CHARLOTTE - MECKLENBURG
PLANNING COMMISSION

DATE: August 16, 2006

SUBJECT: Administrative Approval for Petition No. 2006-22 by Live Oak Development Partnership, LLC.

SHEET NUMBER  
RZ-1

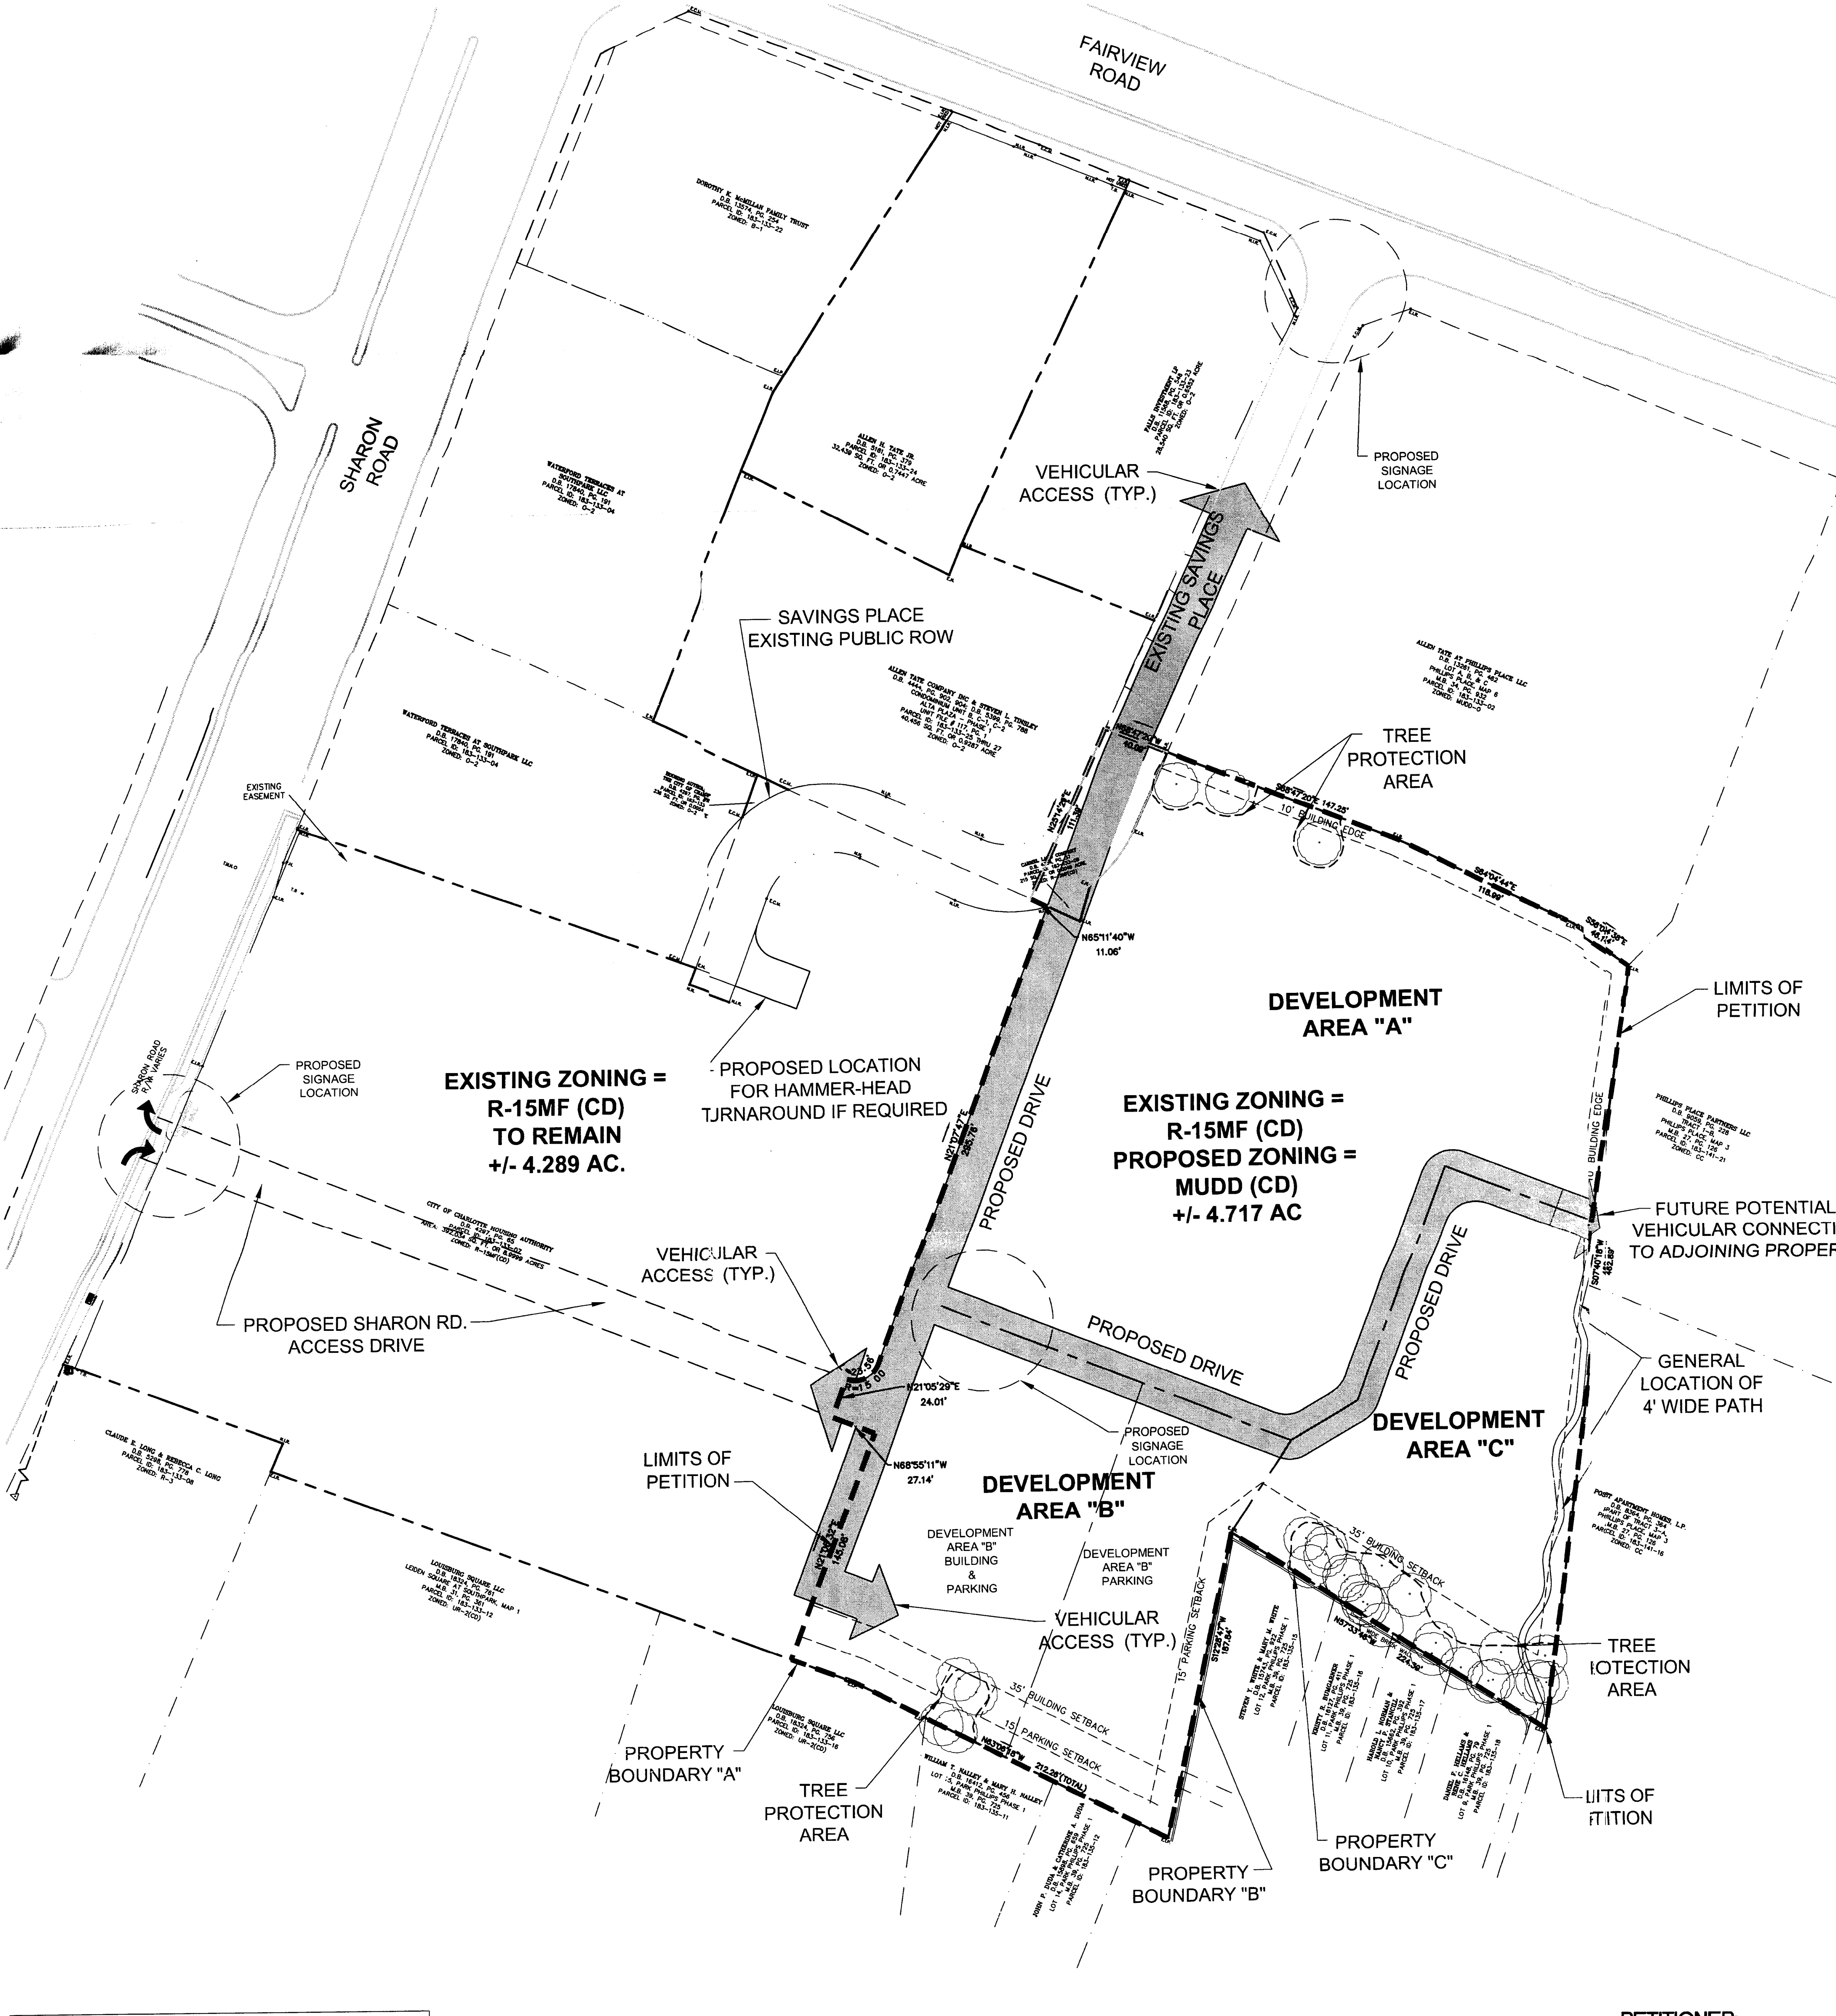
Attached are revised plans for the above petition. The plans have been revised to allow balconies, within buildings constructed within area "B", on the first and second level facing south toward boundary "A". Since this change is minor, I am administratively approving these revised plans. Please use these plans when evaluating requests for building permits and certificates of occupancy.
